**RE: Access Logistics Park, 884-928 Mamre Road, Kemps Creek – SSD 17647189
Consolidated Stakeholder Engagement & Response to Submissions**

TABLE 1 RESONSE TO TFNSW COMMEMTS (DATED 23 DECEMBER 2022)	
Agency Comment	Response
Intersection Design and Further Information Request.	
1. TfNSW requires verification that the deceleration and acceleration lanes will satisfy Austroads requirements. TfNSW Road Design team have recommended that the deceleration lane be extended to reflect the expected traffic volumes, articulated vehicle movements, road gradients and speed of travel. An additional shoulder area is also to be provided. In addition, the ultimate arrangement needs to be consistent with the local road network in Mamre Road Precinct Development Control Plan. TfNSW requires the southbound lanes to remain consistent with MRUS2 strategic design, and the deceleration lane to be included within proposed verge and developer owned land.	The LILO design plan has been amended to ensure deceleration lane satisfies Austroads Requirements. As advised, design plan has been amended and an additional shoulder area has been provided (refer to the amended design plan (2021_19_SD_0001_SK0007D Issue

**Annexure 1 – LILO Strategic Design 2021\_19\_SD\_0001\_SK00014 Issue B**

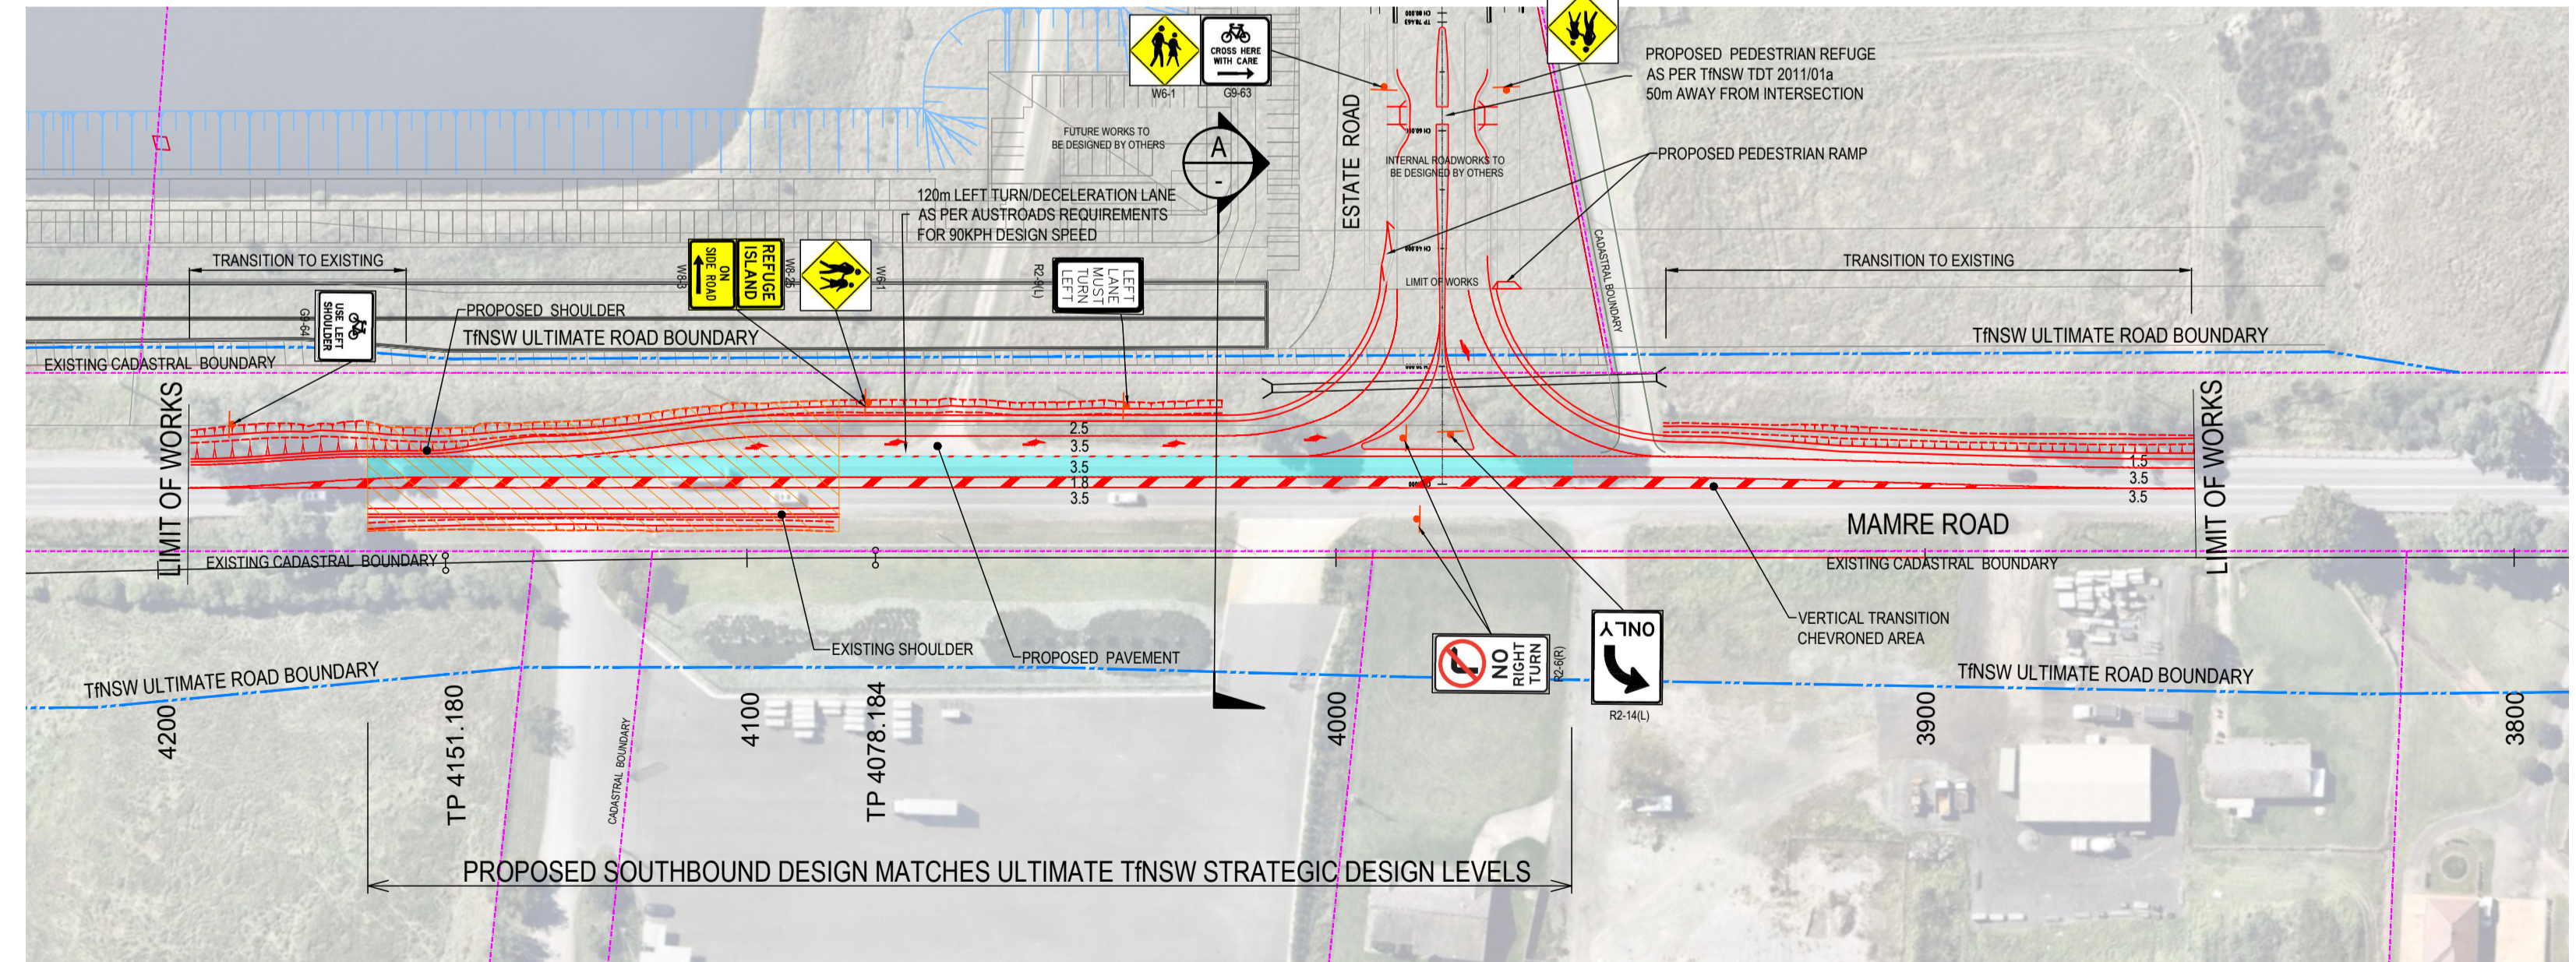
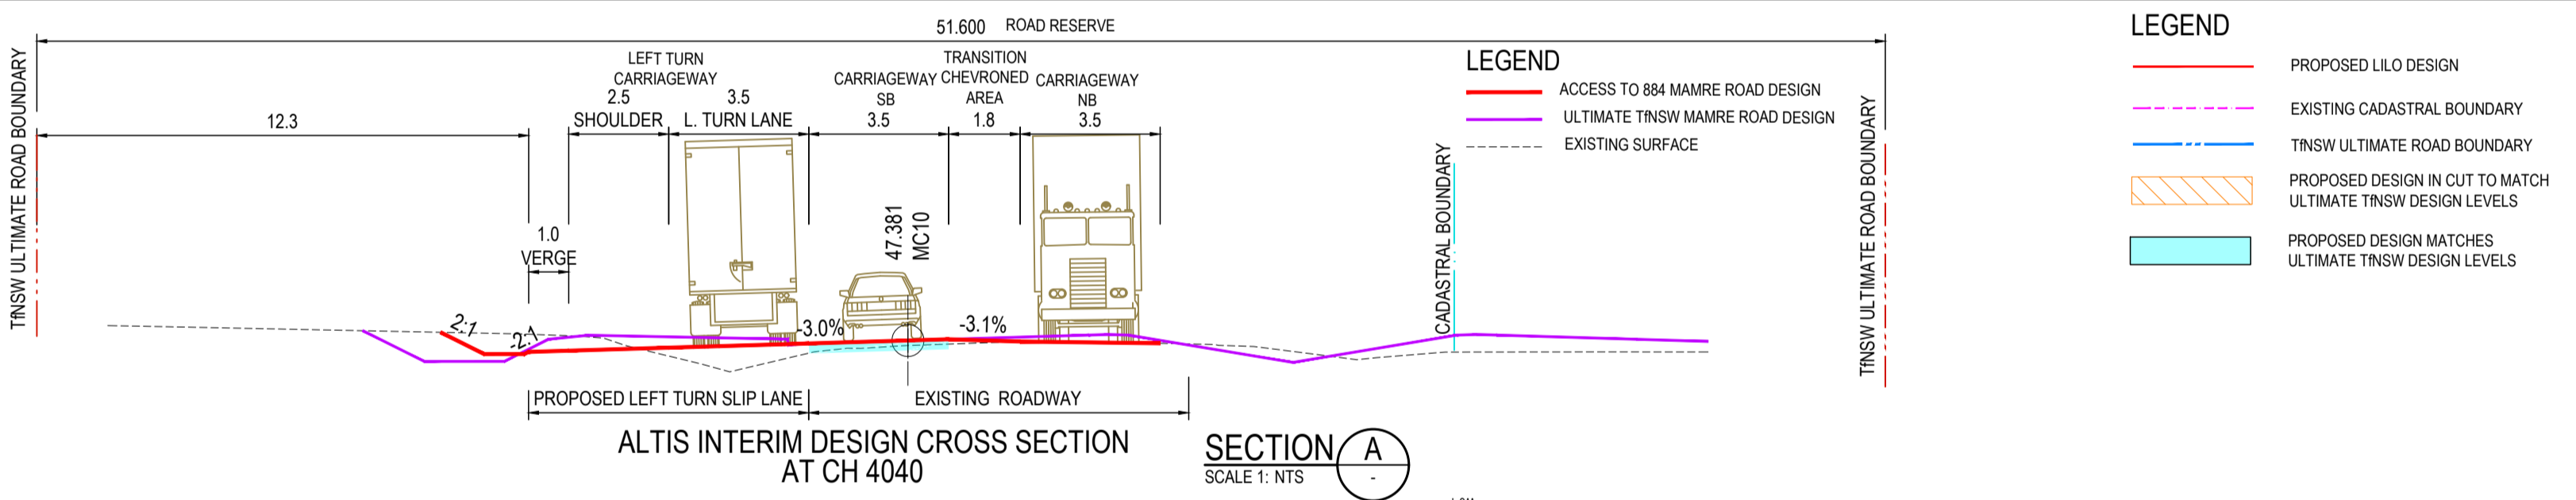
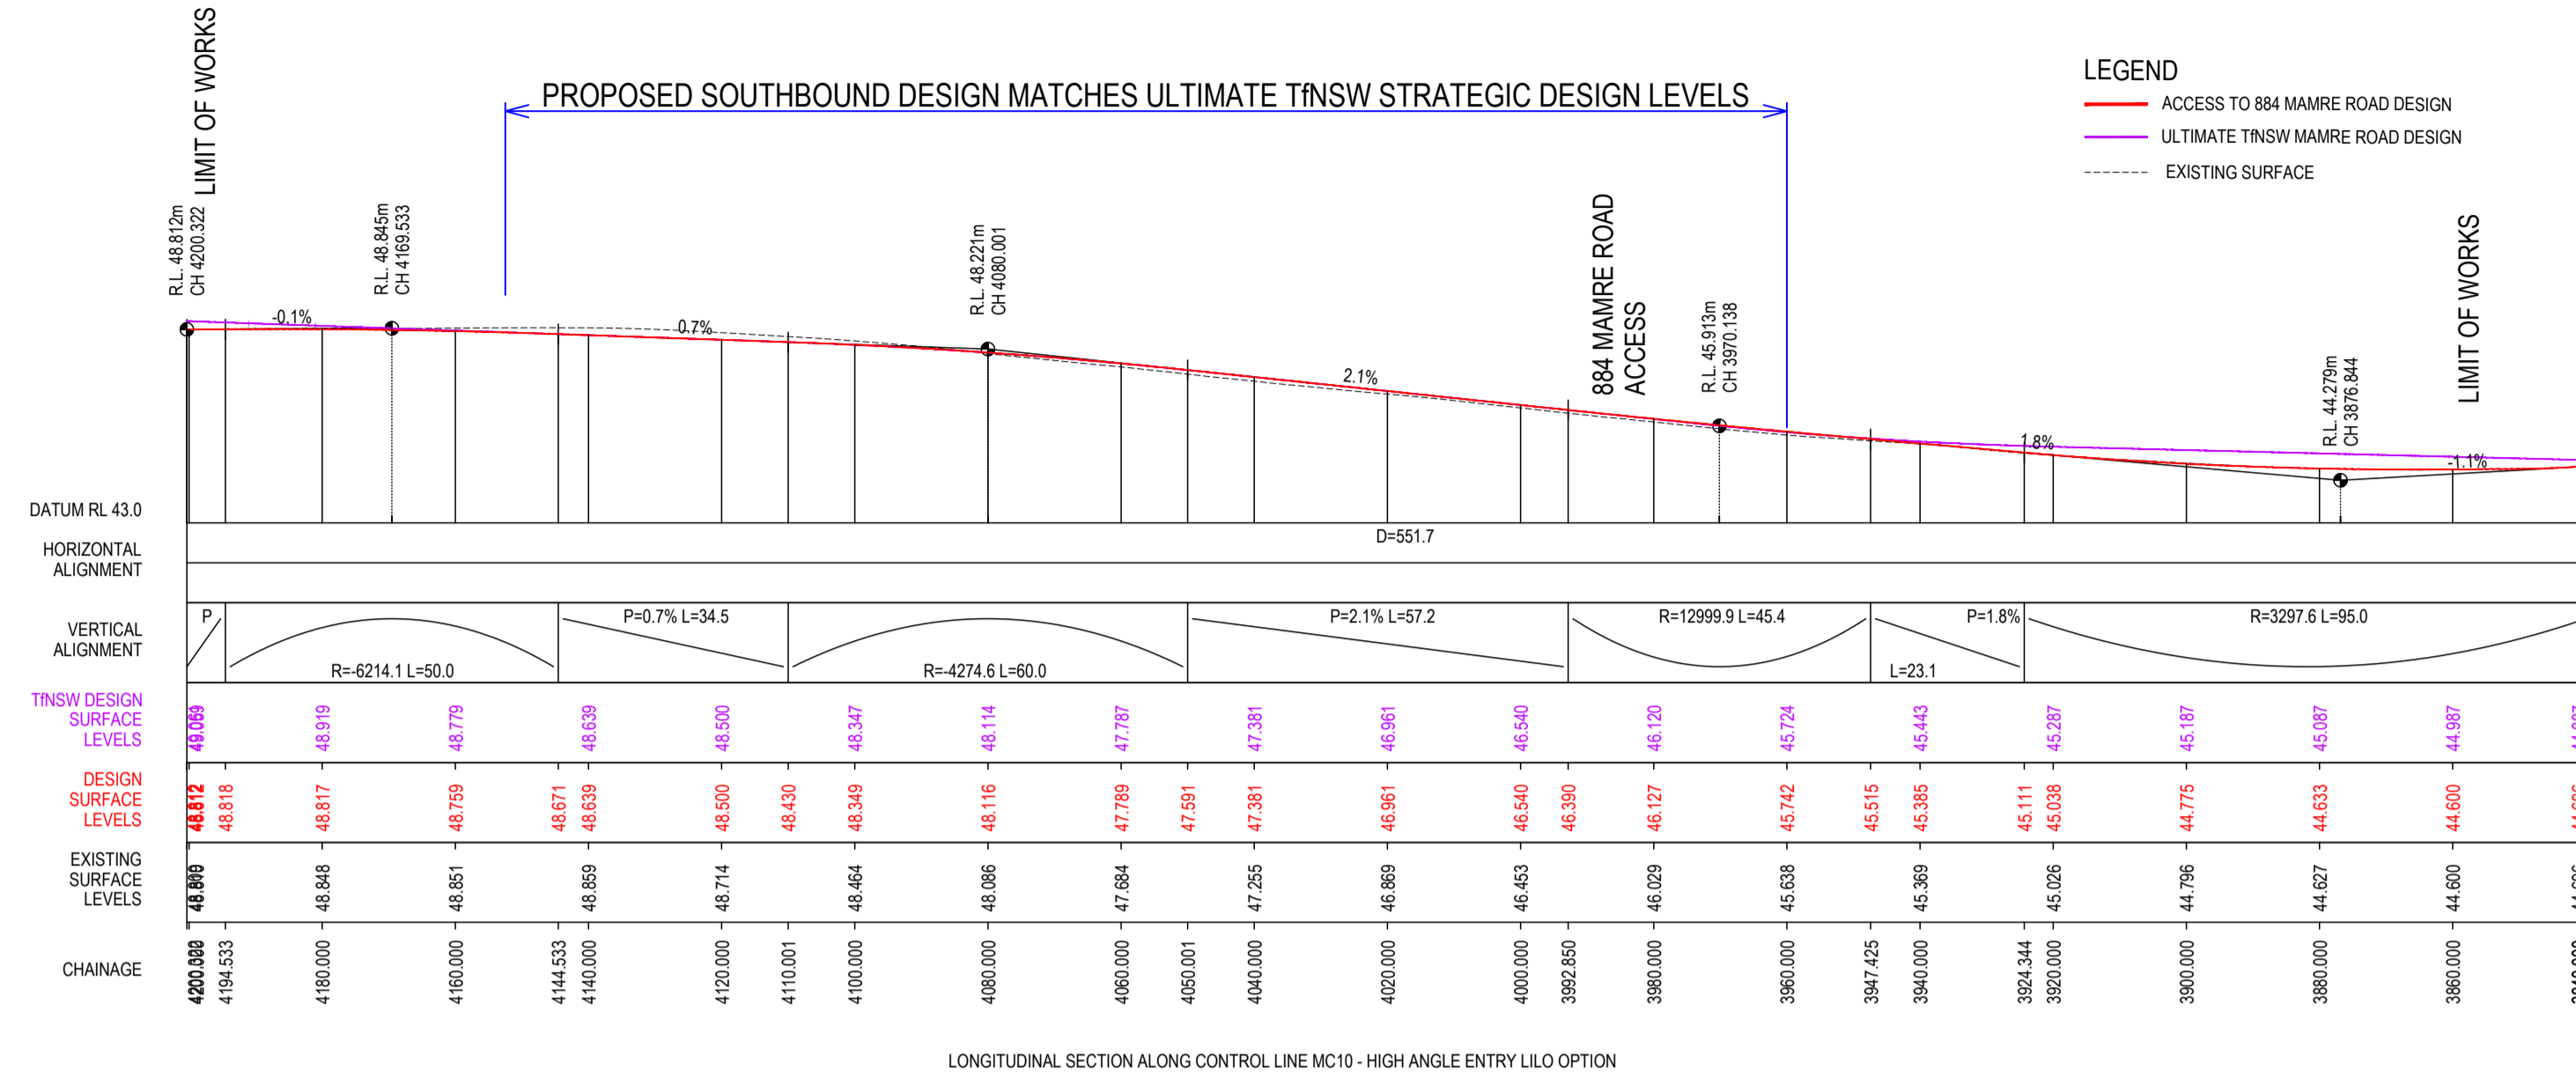
3. The informal staging of the proposal (temporary intersection design/post completion) includes a number of sacrificial works that will require additional funding and timescale to complete. TfNSW is concerned that the interim measures will be inadequate and will involve additional construction delays to achieve the completed intersection. A plan that visually presents the proposed temporary works and final arrangement should be developed and provided to TfNSW that prioritises reducing sacrificial works Additional information should be provided to address the above.	The LILO intersection is permanent infrastructure and has been included within the precinct traffic modelling and the DCP road network. MU group have demonstrated in the latest design plans (plan 2021_19_SD_0001_SK0007D Issue D) the LILO arrangement will not have any impact on the proposed upgrade of Mamre Road to two lanes by TfNSW which forms part of the ultimate Mamre road upgrade plans. With the design completed in accordance with Austroads requirements with 120m deceleration and 320m acceleration lane the design is considered to be adequate to service the proposed development and the broader precinct. With the LILO design confirmed as not impacting the through lanes on Mamre road and its ultimate operation, the horizontal geometry is deemed adequate to avoid sacrificial works. The proposed design was developed to match existing levels and to minimise any sacrificial works from level changes that form part of the ultimate Mamre road upgrade design, however these levels have not been provided. A change in levels from the proposed LILO and the ultimate Mamre road upgrade level is not looked at as sacrificial work, but rather further integration works to match the levels for this infrastructure that will proceed the ultimate design by some time and form the base for the ultimate levels. It is noted that there is no Shared Path proposed in TfNSW ultimate design for Mamre Road fronting the subject site. To minimise any sacrificial works, the proposed Shared Path has now been removed from the design and extra 2.5 - 3m shoulder has been included in the design. The amended design plan (2021_19_SD_0001_SK0007D Issue D) demonstrates that a footway can be incorporated in the future by TfNSW once the final levels are set and the ultimate Mamre road upgrade design is finalised. Please refer to the amended design plan, which visually indicates the proposed works for LILO intersection which has been overlayed on the TFNSW Ultimate design for Mamre Road.
